From: [REDACTED]
To: [REDACTED]
Cc: [REDACTED]
Subject: RE: 23/1195/LB Tower Farmhouse, Station Road, Tower End, Middleton, Norfolk
Date: 18 August 2023 08:30:10
Attachments: [image003.png](#)
[image004.png](#)
[image005.png](#)
[image006.png](#)

Thank you for informing the Georgian Group of an application to undertake works of demolition and alteration to the above grade II listed building. The Group wishes to register its formal objection to these proposals for the following reasons.

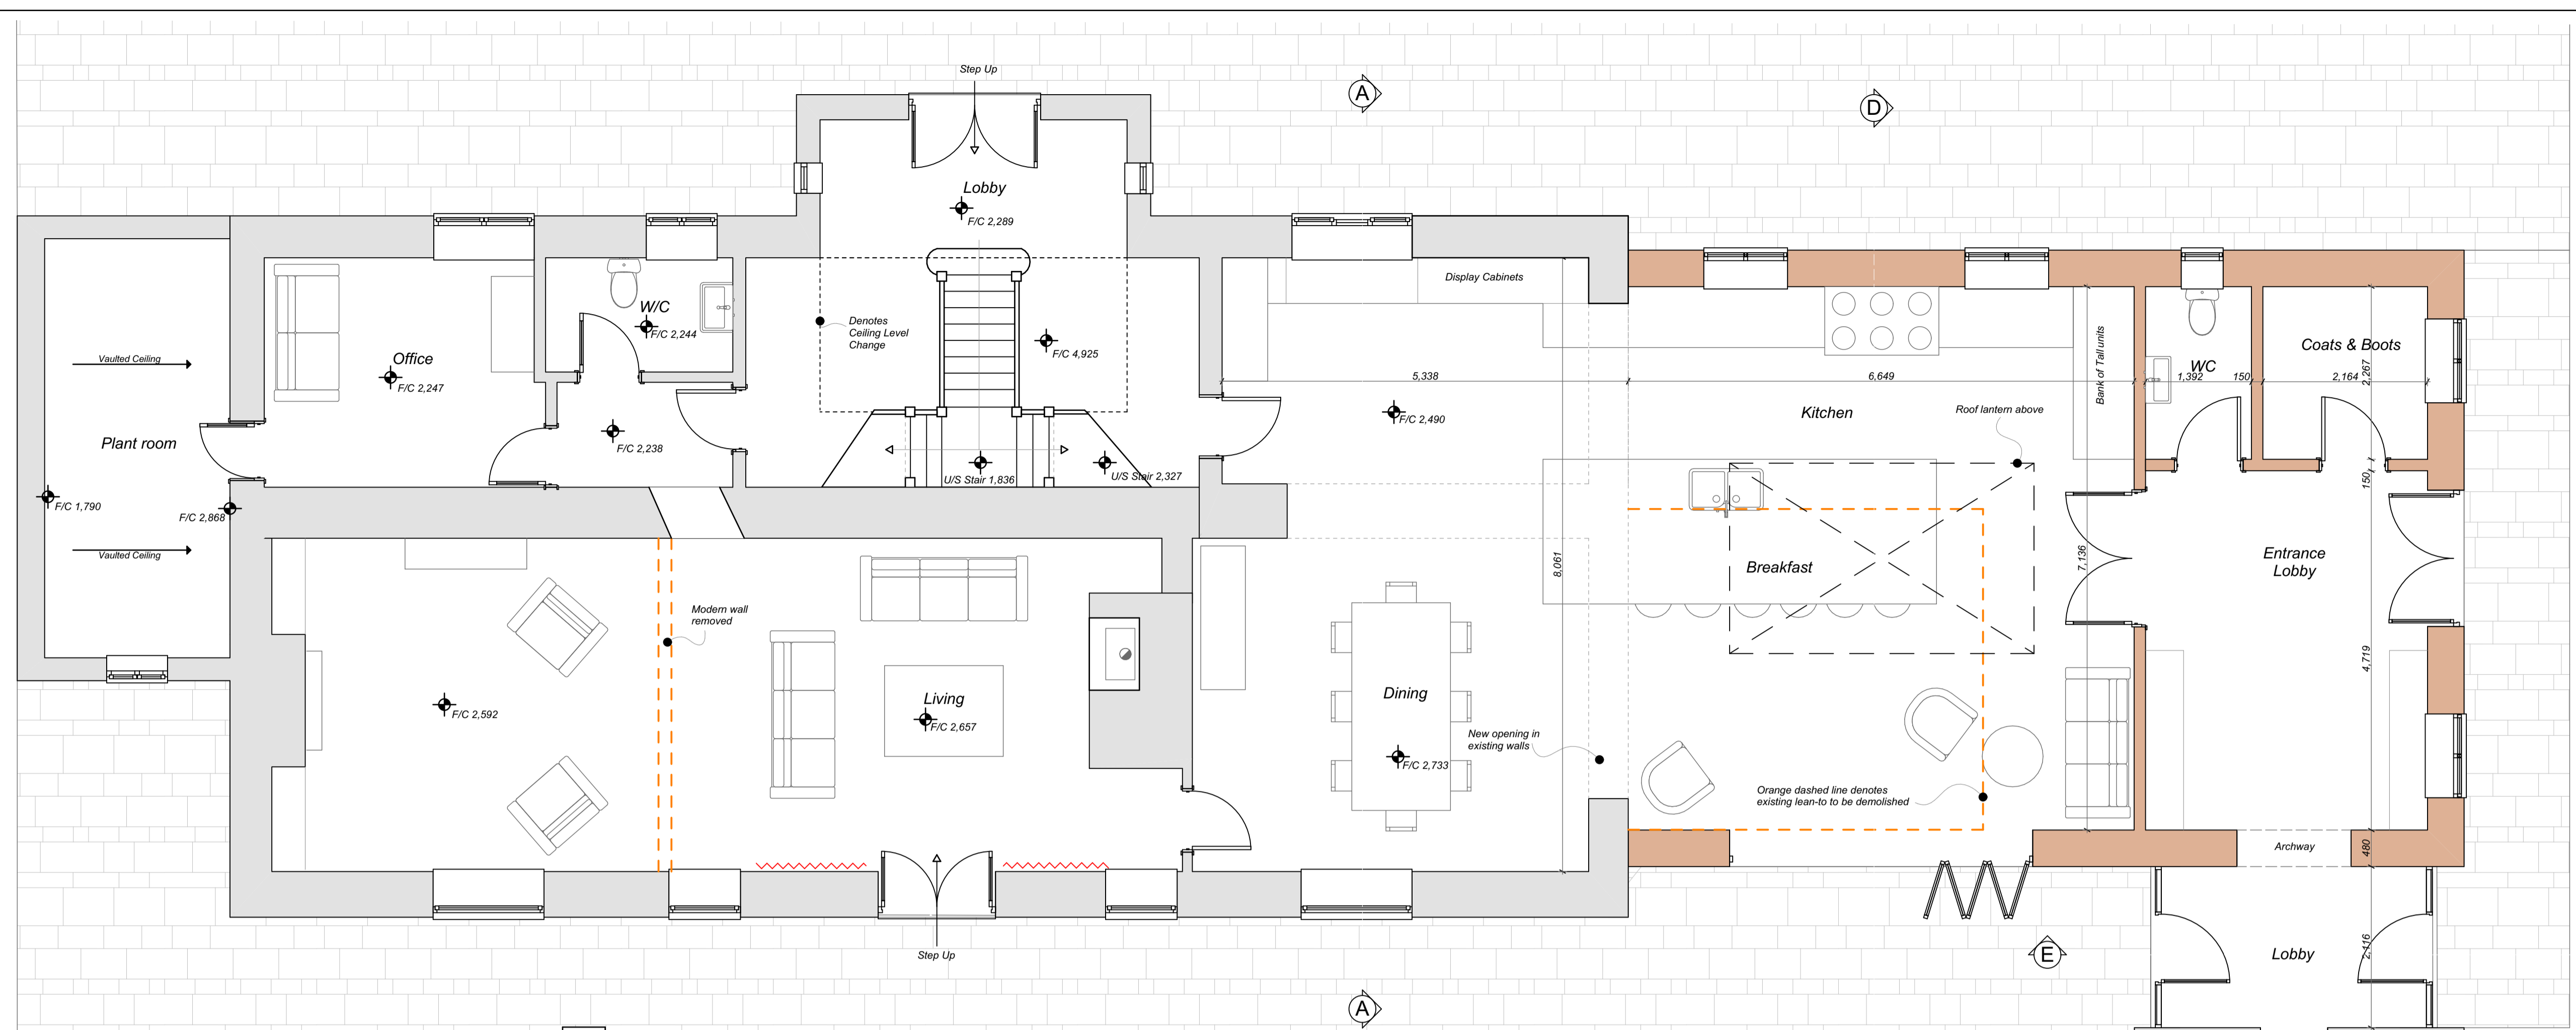
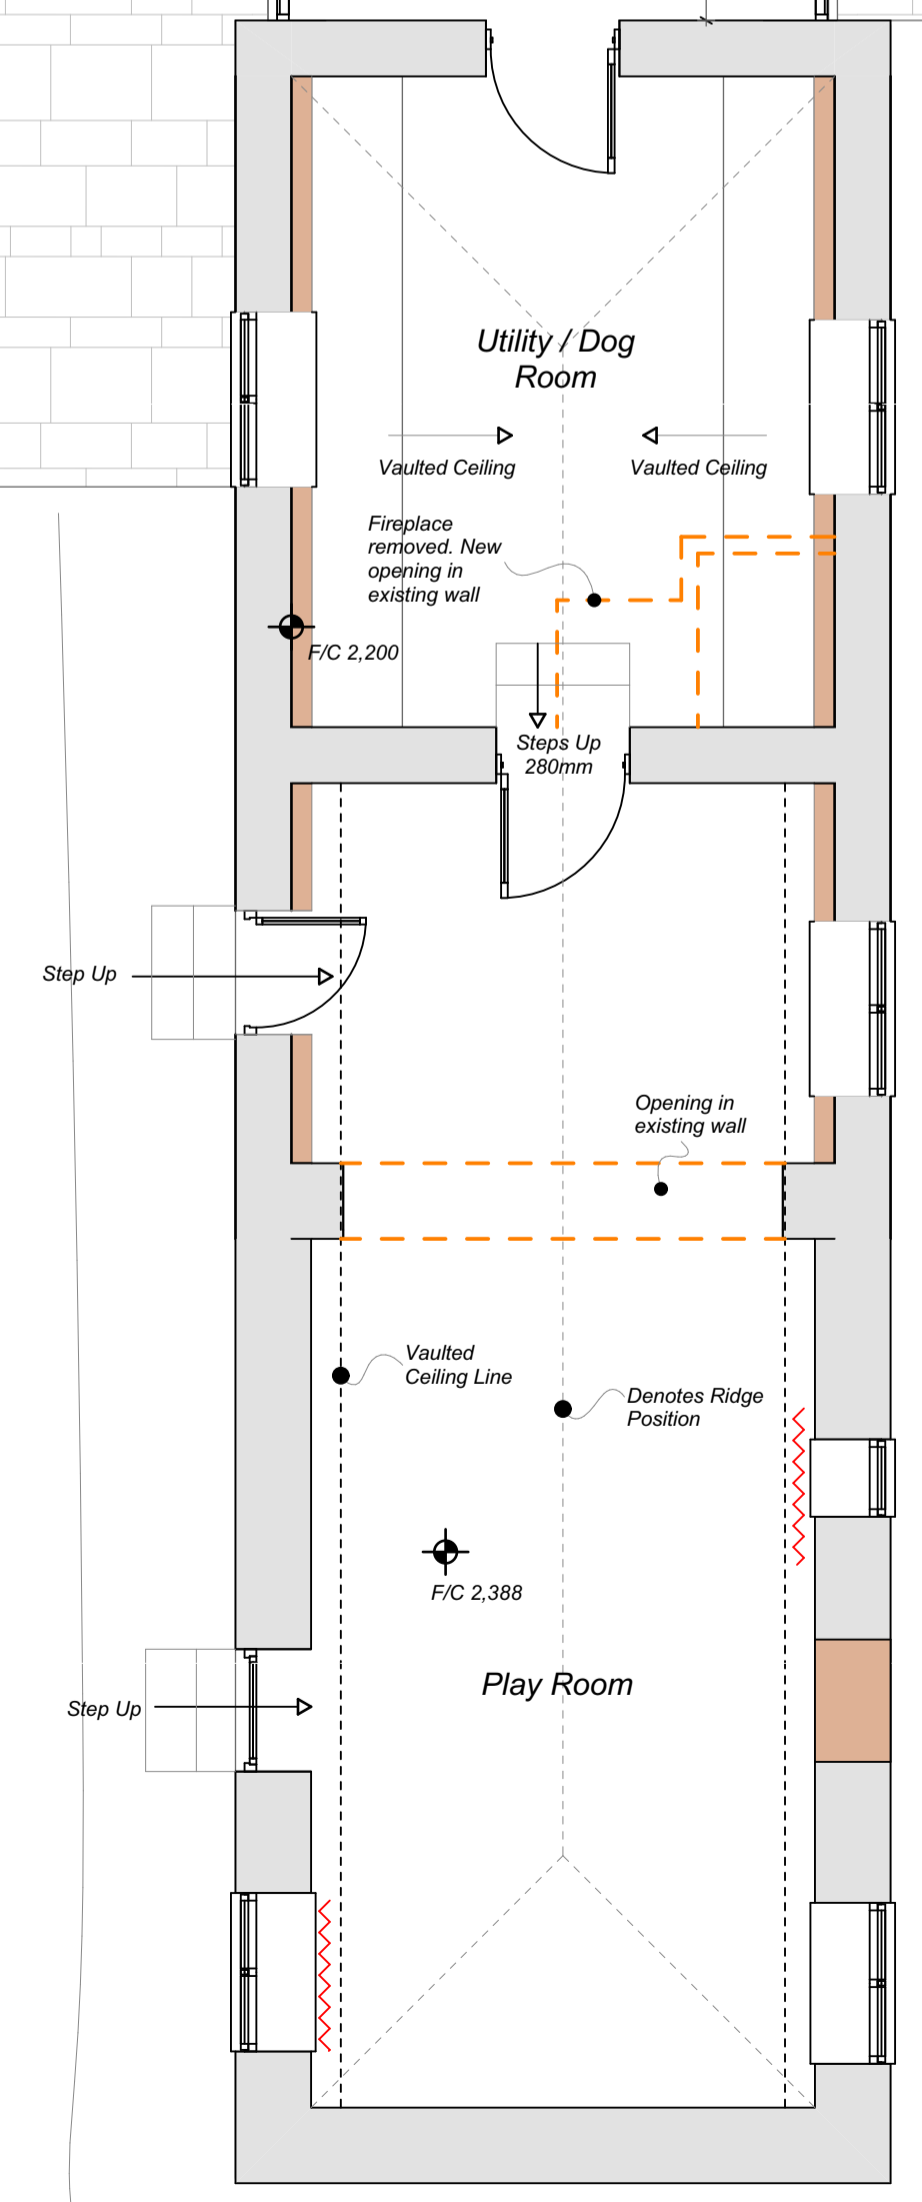
It is proposed to demolish a single storey nineteenth century wing and replace it with a much larger structure, also removing much of the original gable end wall of the farmhouse and a chimneybreast at ground floor level. Much of the remains of an historic internal partition would also be removed together with a further partition which the applicant describes as 'modern'. In their totality these proposals will cause a significant degree of harm to the historic fabric, planform, and significance of the listed building, adding to the cumulative detrimental impact of the alterations undertaken post 2015.

brick service wing as this will remove further evidence of how the building developed and functioned in the nineteenth century. We note that no evidence has been provided that the existing structure cannot be adapted to partially meet the applicant's needs for additional accommodation. The Group also has serious concerns about the proposal to remove the bulk of the gable end wall at ground floor level together with the chimneybreast. This aspect of the proposals will cause serious harm to the historic planform of the listed building and should be deleted from the scheme. The loss of the door opening into the early nineteenth century service wing will also further erode evidence of how the building functioned in the nineteenth century.

The Group has concerns about the size of the proposed replacement structure in relation to the existing farmhouse, and about its relationship to the adjacent outbuilding. Extending the new wing to the north will also lead to the loss of an historic window opening within the gable. The proposed roof lantern is a particularly assertive element of the proposed design which will detract from the setting of the original listed building.

Evidence should be provided that the partition within the living room which is to be removed is indeed of relatively recent date. Information should also be provided to explain the age and significance of the outbuilding to which the house is to be connected, and to explain the impact of the proposed alterations upon its significance. We also note that no information has been provided to explain the impact of the demolition of the wing and the erection of a larger new structure on the setting of the other historic buildings which form part of the former farmstead complex.
